Rezoning Transportation Analysis

Petition Number: 2023-124

Revision Log:

| Date | Description |
|----------|-------------------|
| 11-21-23 | First Review (IW) |

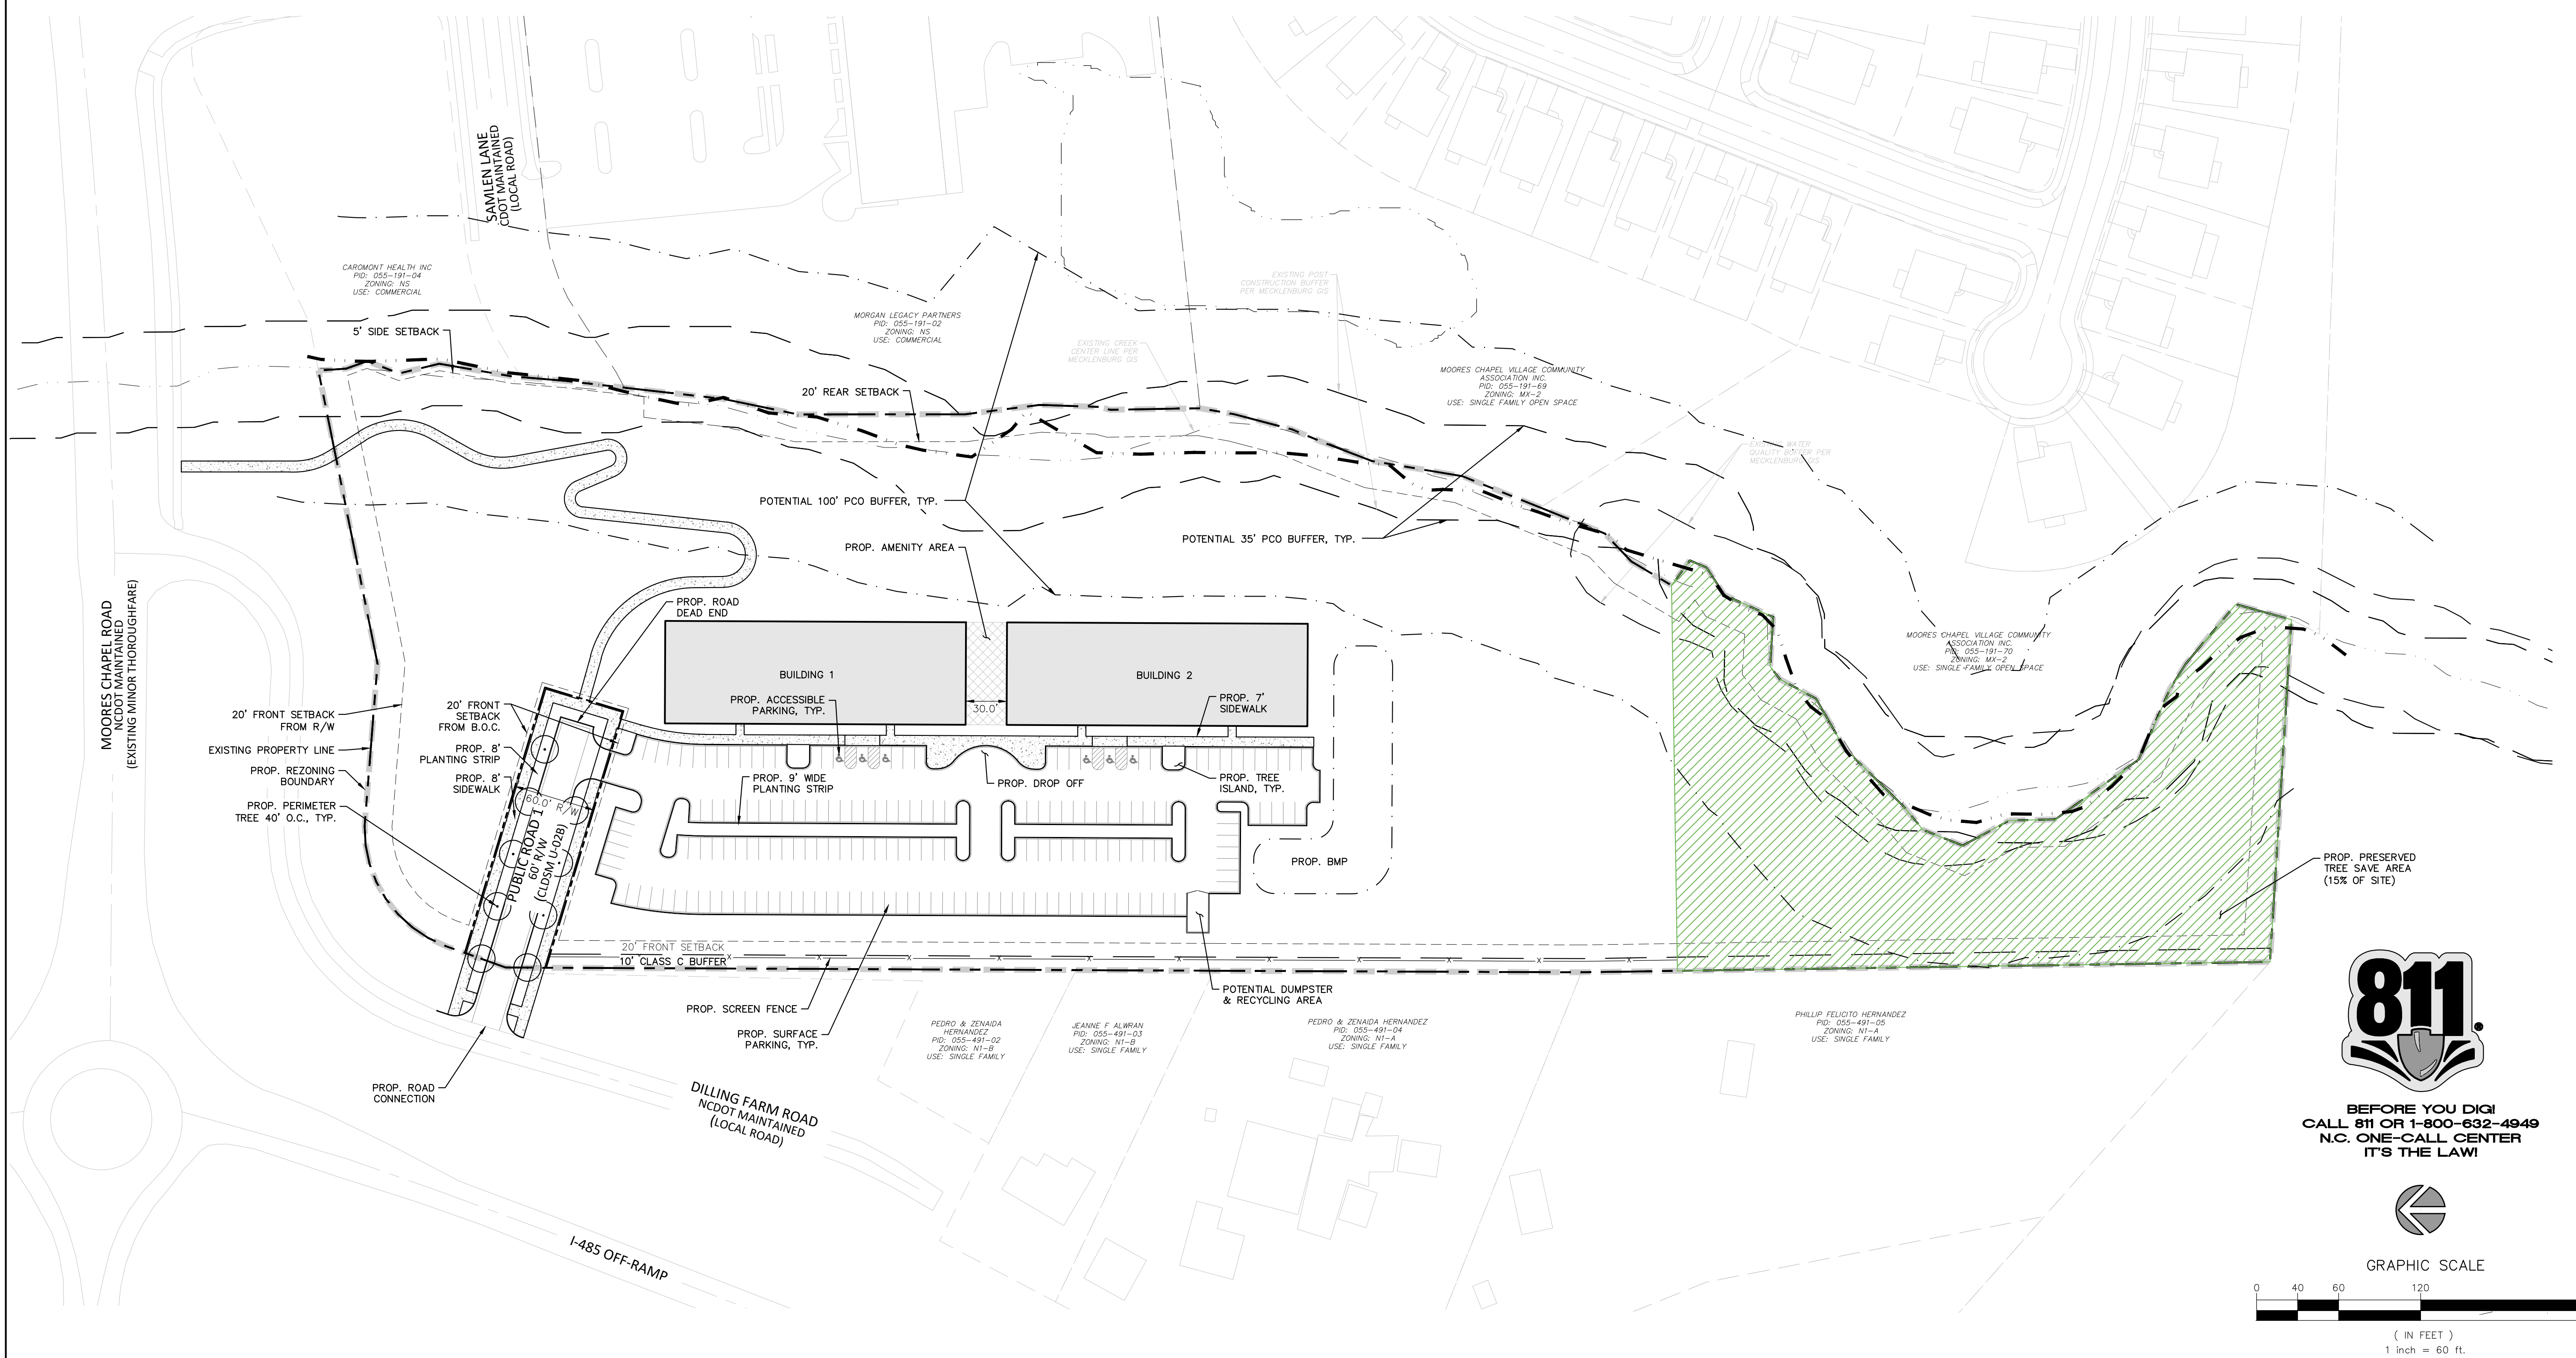
1. Curblines:

- a. **Moore's Chapel Road:** Label and dimension the location of future curb and gutter to be 38' from centerline.

- b. **Dilling Farm Road:** The location of the future back of curb and gutter to be 17.5' from centerline. The sight plan is to commit to installing as well.

Label and dimension the curb and gutter from the centerline for each road on the site plan.

- 3. Revise site plan and conditional note(s) to commit to dedicate 33.5' of right-of-way from the road centerline along Dilling Farm Road. The site plan shall label and dimension the right-of-way from the road centerline.

- 5. Revise site plan and conditional note(s) to commit to constructing an 8' planting strip and an 8' sidewalk per Article 33 of the UDO and CLDSM U-03A1 along Dilling Farm Road.

6. Revise site plan and conditional note(s) to commit to making "Public Road 1" a private road per coordination with Subdivision.
7. Add a conditional note specifying "the Petitioner shall dedicate and convey in fee simple all rights-of-way to the City before the site's first building certificate of occupancy is issued. CDOT requests rights-of-way set at 2' behind back of sidewalk where feasible."
8. Add a conditional note specifying "All transportation improvements will be approved and constructed before the site's first building certificate of occupancy is issued."
